Application for a non-material amendment following a grant of planning permission.

3/2021/0787

ROOF LIFT; TWO-STOREY EXTENSION TO REAR; TWO DORMERS TO FRONT; GLAZED ATRIUM; ROOF OVER EXISTING GARAGE; RE-RENDERING AND GREY WINDOWS & DOOR FRAMES

AMENDMENT TO CONDITION 2 - APPROVED DRAWINGS

Client:	Mr & Mrs Croft		
Project:	Proposed Alterations Small Acre Osbaldeston Lane Osbaldeston		
Drawn by:	1:100	21.09.20	PD
Scale of A4:	1:100		
Project no:	1179 - 09		
Rev:	P3

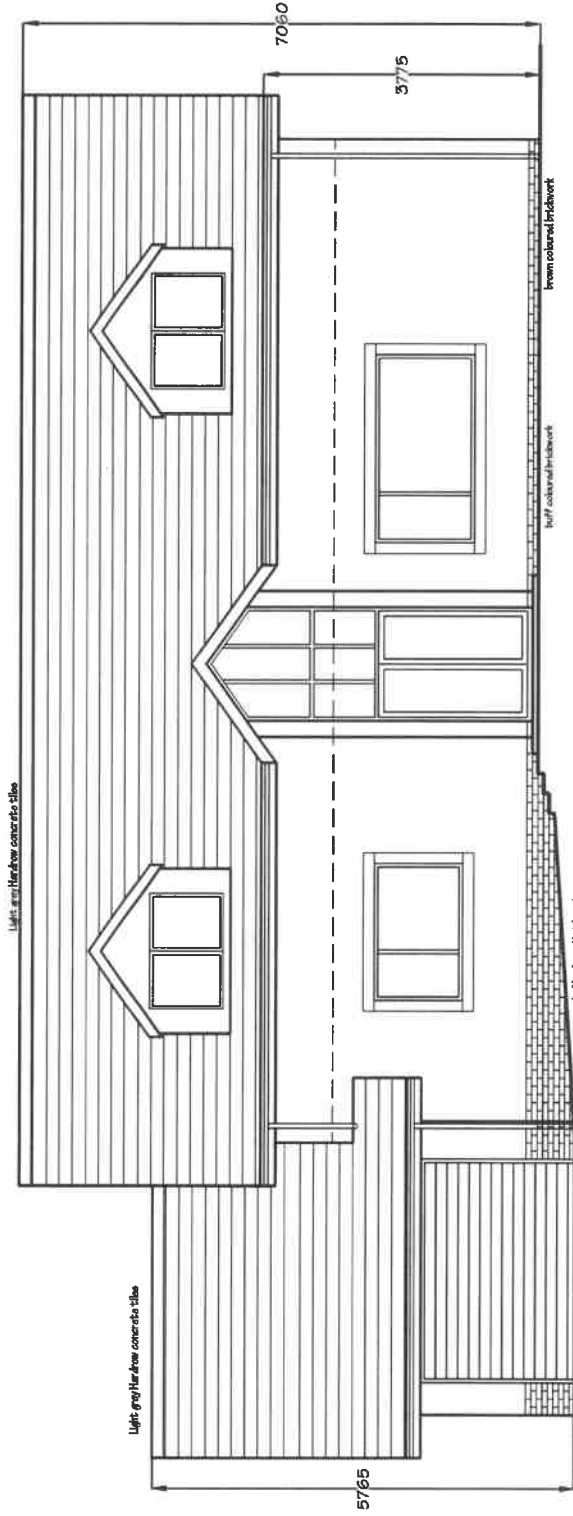
VARIATIONS - PROPOSED ROOF HEIGHT TO BE INCREASED BY 225mm

TO PROVIDE UPDATED DRAWINGS FOLLOWING DESIGN ALTERATIONS AS A RESULT OF STRUCTURAL DESIGN CHANGES TO THE FIRST FLOOR JOIST DESIGN.

THE INCREASED DEPTH OF THE FLOOR JOISTS HAVE RESULTED IN THE REDUCTION IN HEIGHT OF THE CEILINGS AT FIRST FLOOR LEVEL. THE INCREASE IN THE BUILDING HEIGHT IS REQUESTED TO ACCOMMODATE THESE CHANGES.

1179-09 P3, 1179-10 P3, 1179-11 P3, 1179-12 P3.
